**Application Reference: 2025/1072**

**Site Address:** Homer House, 335 Burton Road, Monk Bretton, Barnsley, S71 2QF

This application seeks full planning permission for the demolition of garage and erection of a two-storey side extension and inclusion of raised patio area to rear of extension.

North East Elevation 1:100

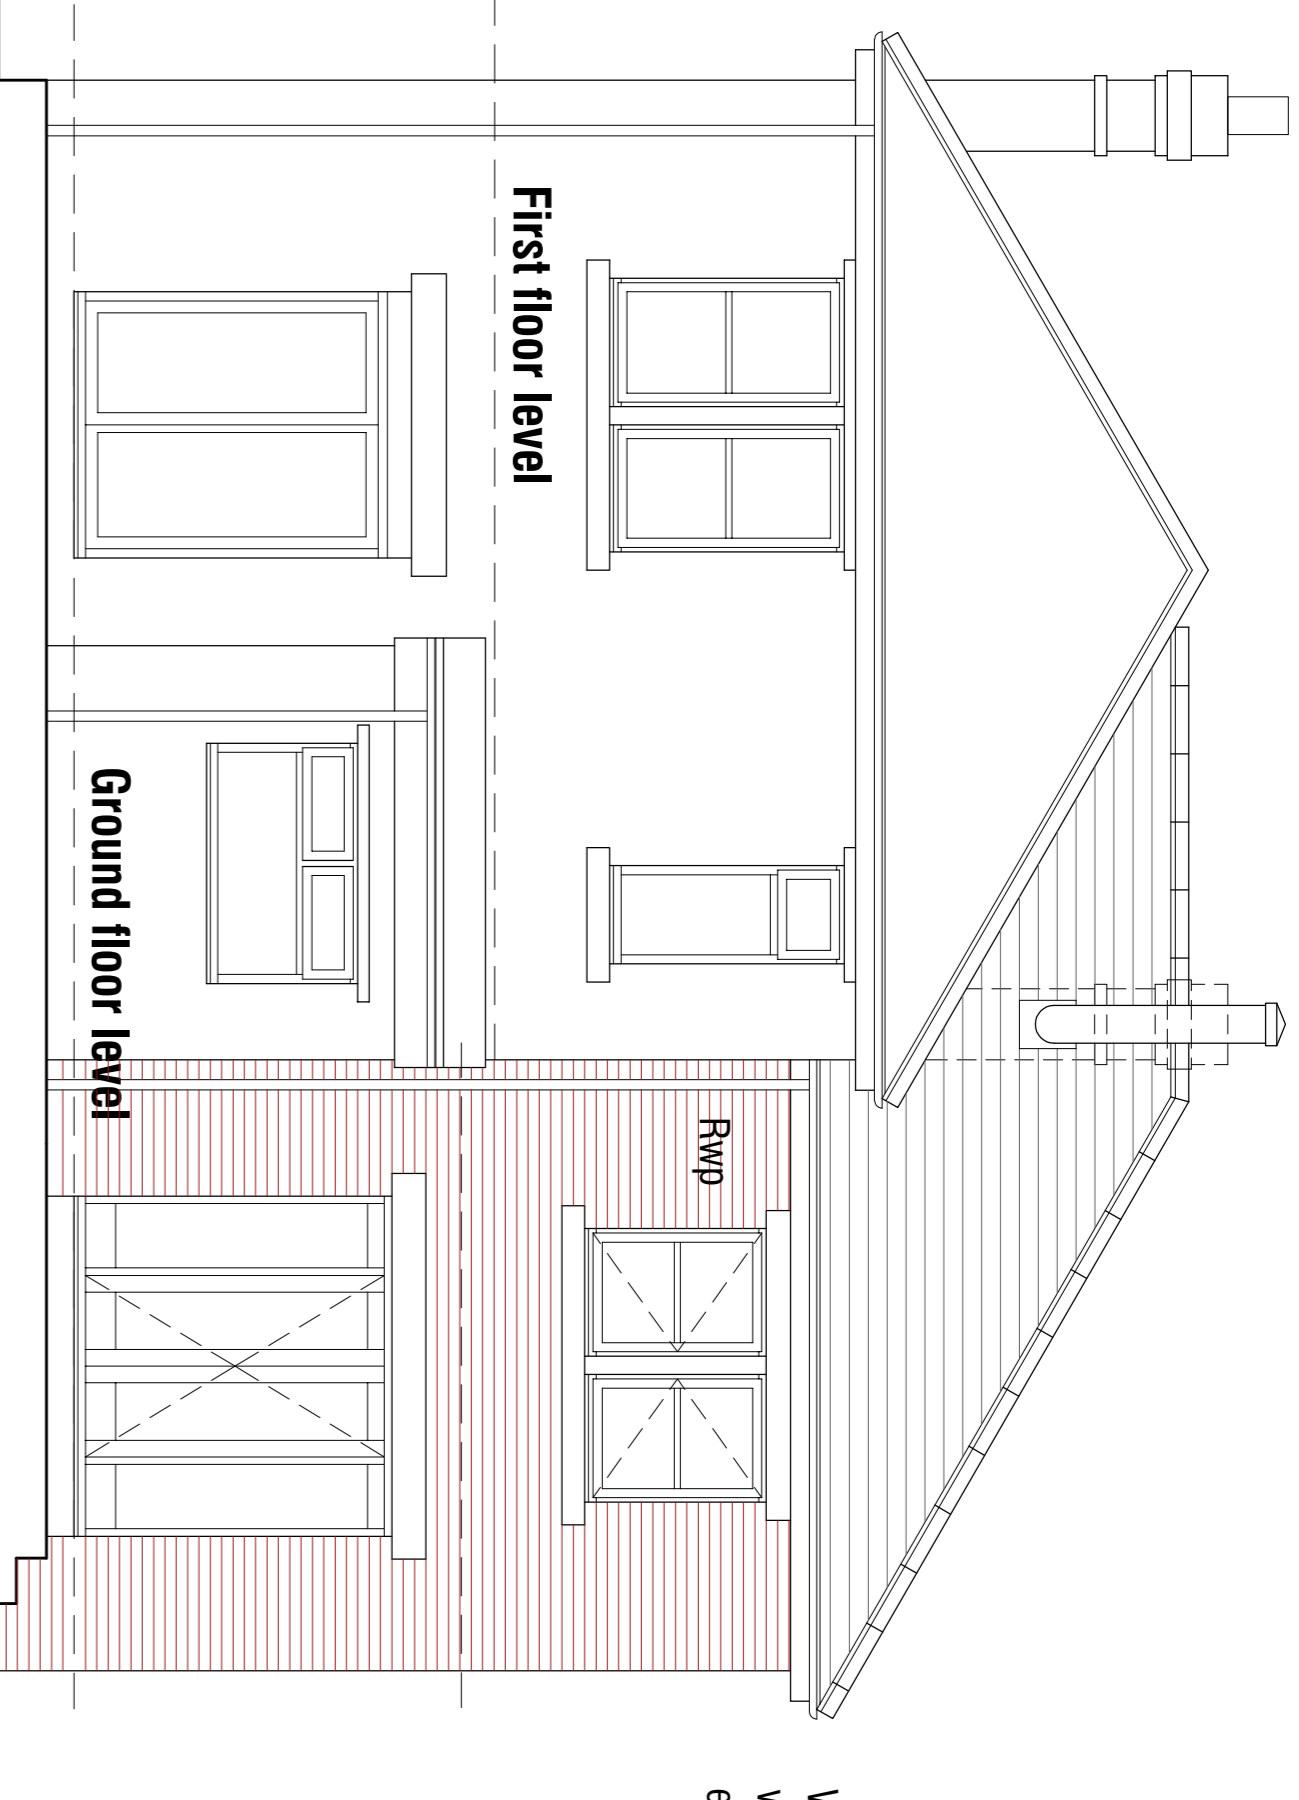
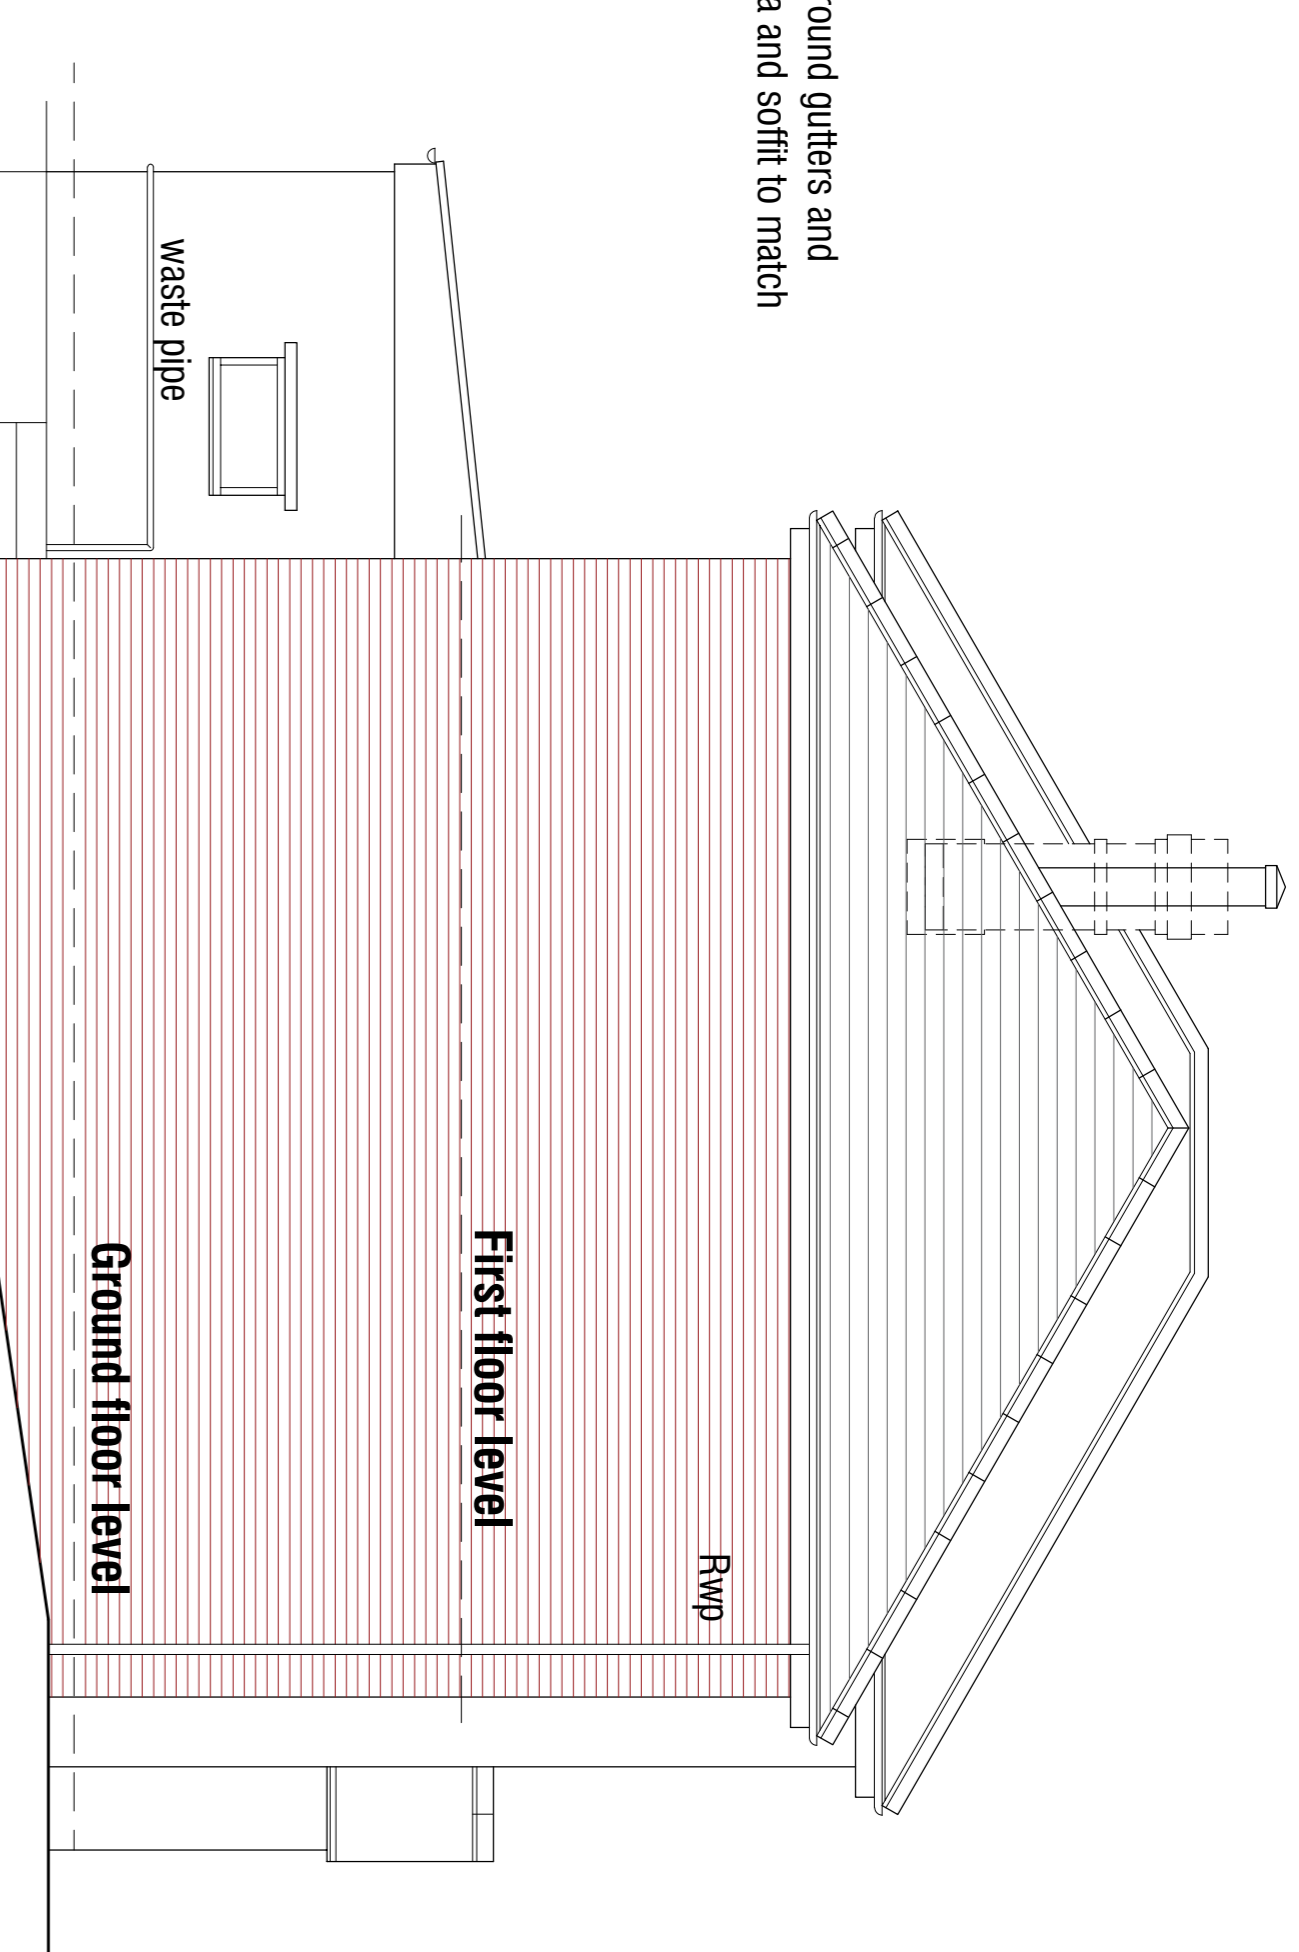
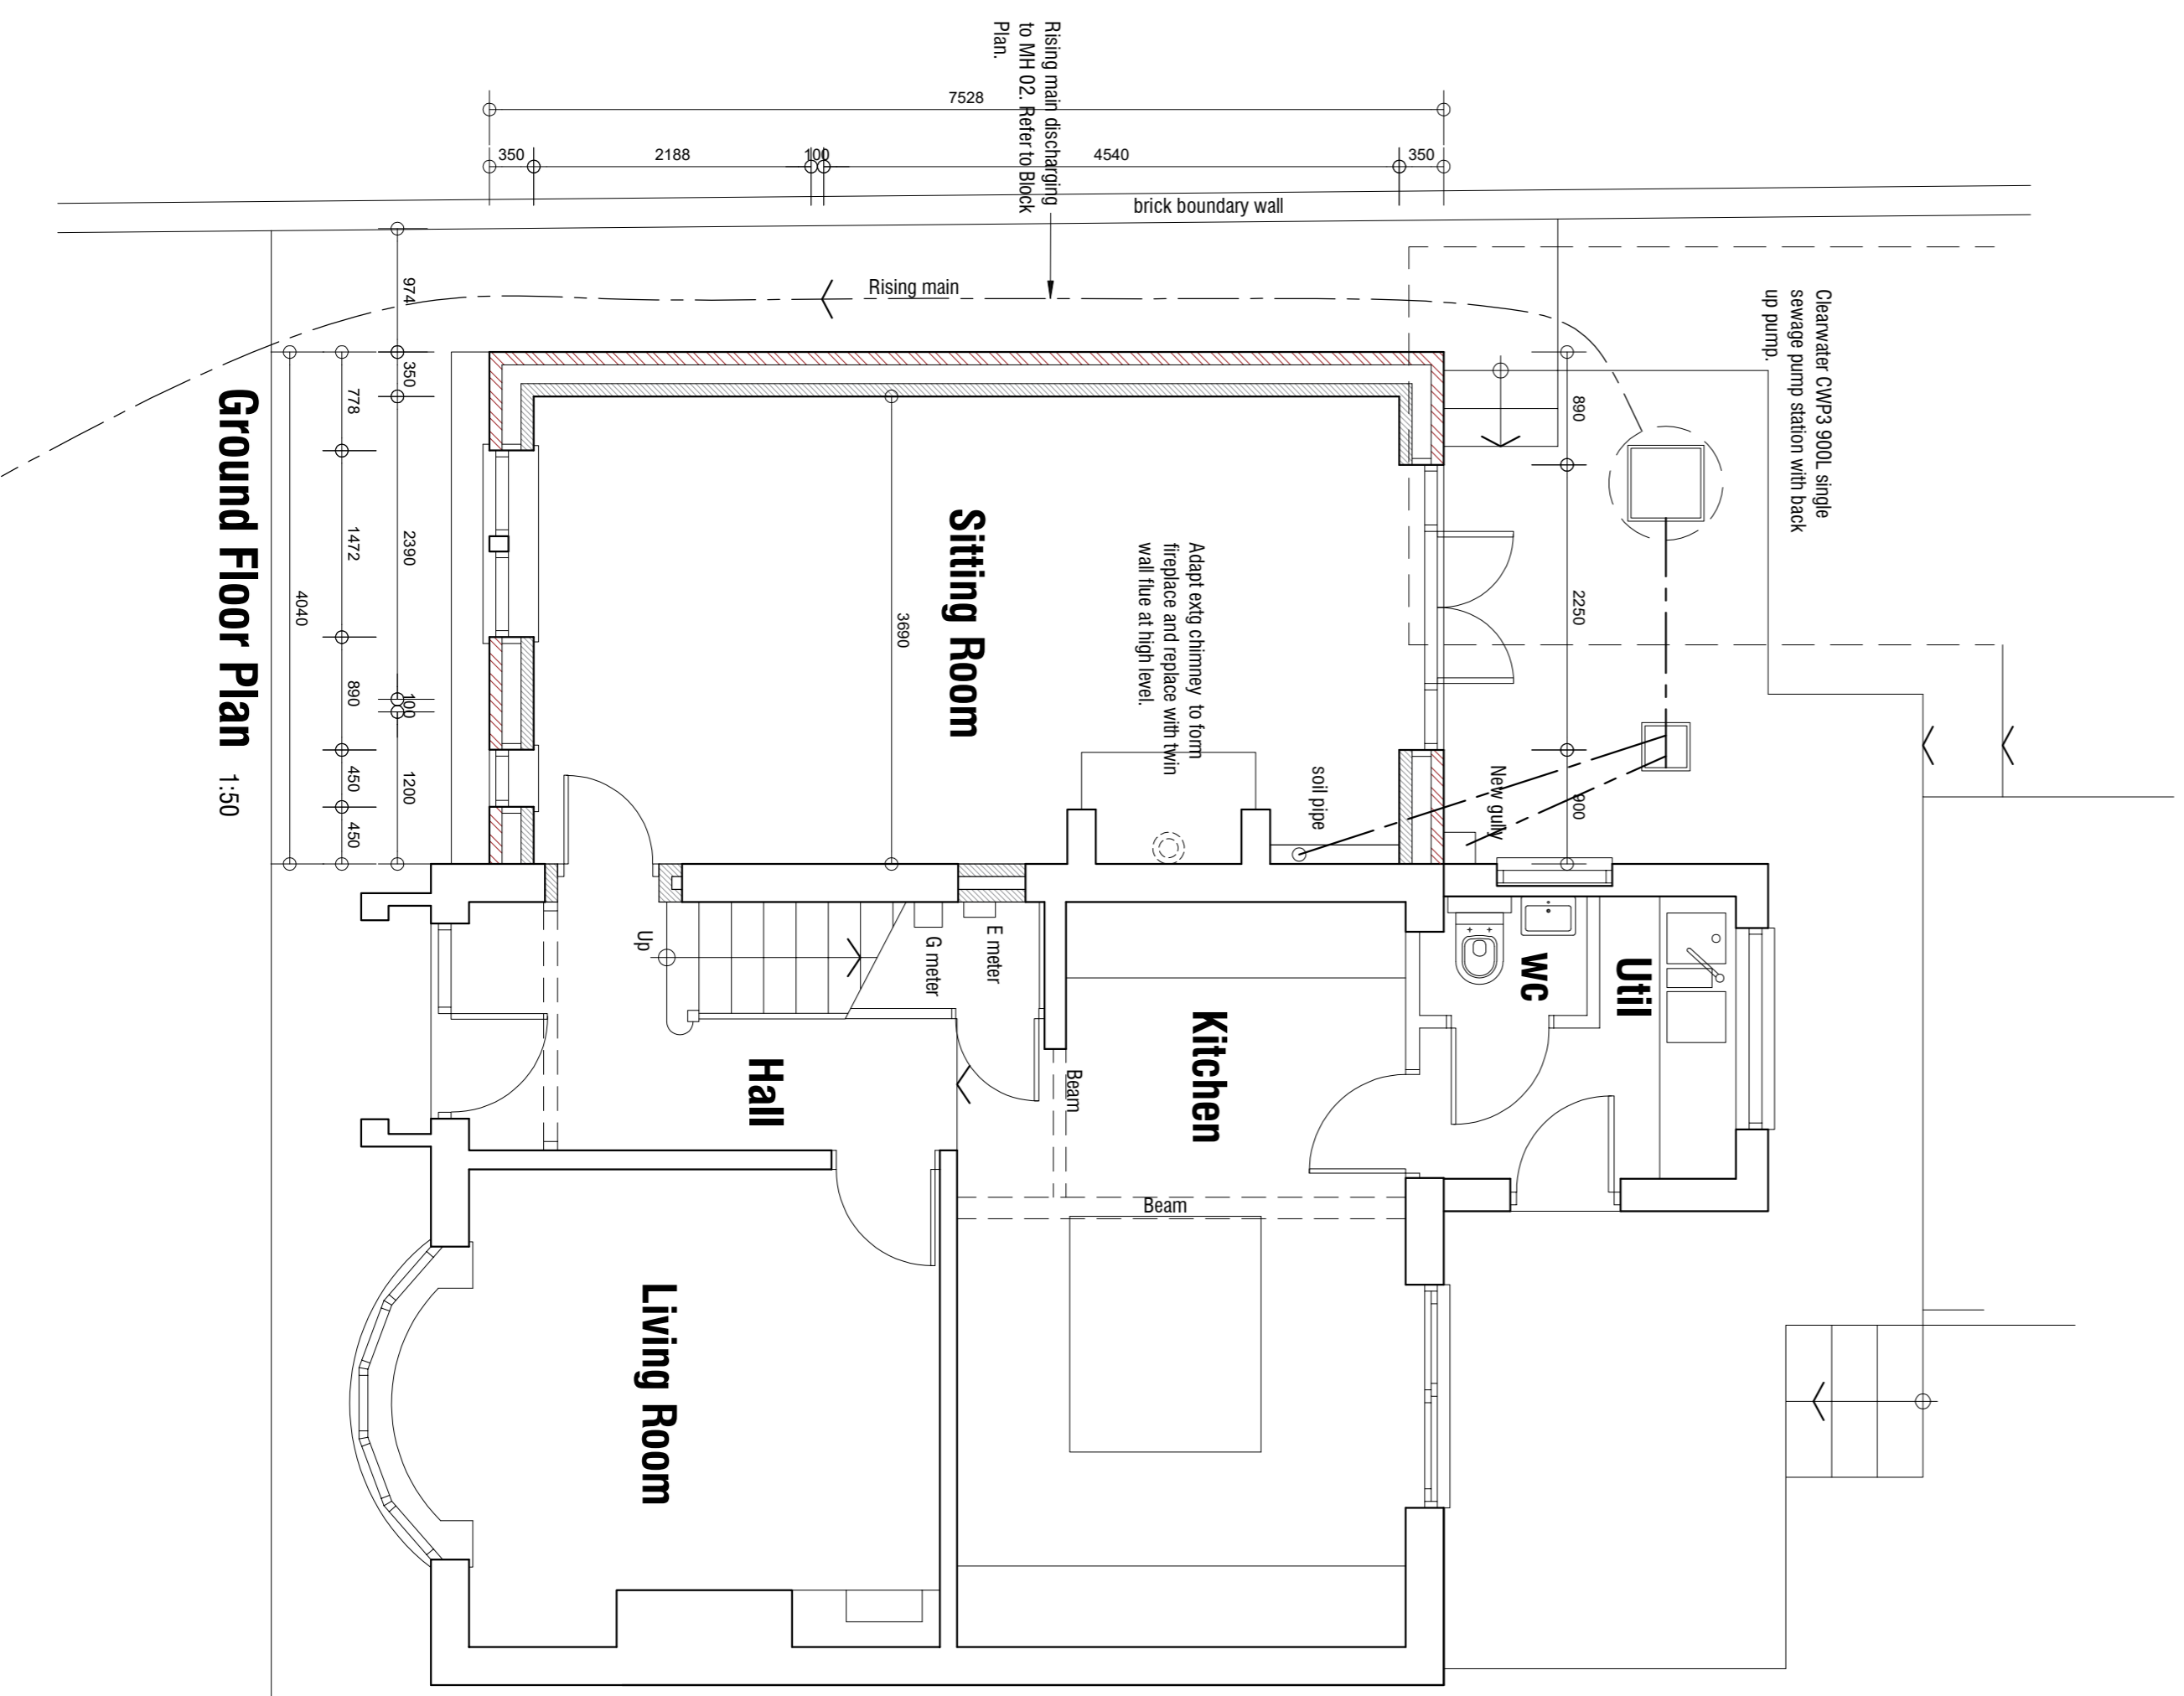
The proposed extension is to be located on the north-eastern side elevation of the dwelling, to the south-west of 335a Burton Road; whilst the extension is to be located to the south of this property it is located within the building line of the original dwelling. It is acknowledged that the extension would project closer to the side elevation of the neighbouring property, resulting in some loss of outlook from the window located on the side elevation. However, side elevation windows are not normally afforded the same level of protection as primary

There are no habitable room windows located on the side elevation of the proposed extension, therefore there would be no increase in levels of overlooking. The windows located on the front and rear elevations do not project closer to the respective boundaries than the existing dwelling and as such the proposal would not increase levels of overlooking to an unreasonable level.

Supplementary Planning Document House extensions and other domestic alterations states that 'the design of a two-storey side extension should reflect the design of the existing dwelling in terms of roof style, pitch materials and detailing and should not have an excessive sideways projection, i.e. more than 2/3 the width of the original dwelling'. In this instance the proposed extension projects 4m from the side elevation and therefore complies with the guidance set out in the SPD.

The document also states that a two storey side extensions should have a set back from the front elevation by at least 500mm, to allow for a vertical break in the roof plane, a lowering of the ridge line and to reduce the terracing effect, the set-back also lessens the unsightly bonding of old and new materials. It goes on to state that the linking or closing the gap between semis or detached houses to give the effect of a terrace, is a detrimental change to the character of the street scene and must be avoided, therefore a side extension should also be set in by one metre from the side boundary with an adjacent property, to further avoid the terracing effect. The proposed extension is set in from the side boundary by 1m and incorporates a set-back of 450mm from the front elevation; this carries considerable weight in favour of the application

The design of the proposed side extension relates well to that of the original dwelling in terms of roof style, pitch and detailing and the materials proposed, in addition the fenestration of the proposed matches that of the original dwelling. This carries considerable weight in favour of the application, and it is therefore considered that the proposed extension is acceptable in terms of visual amenity and in compliance with Local Plan Policy D1.
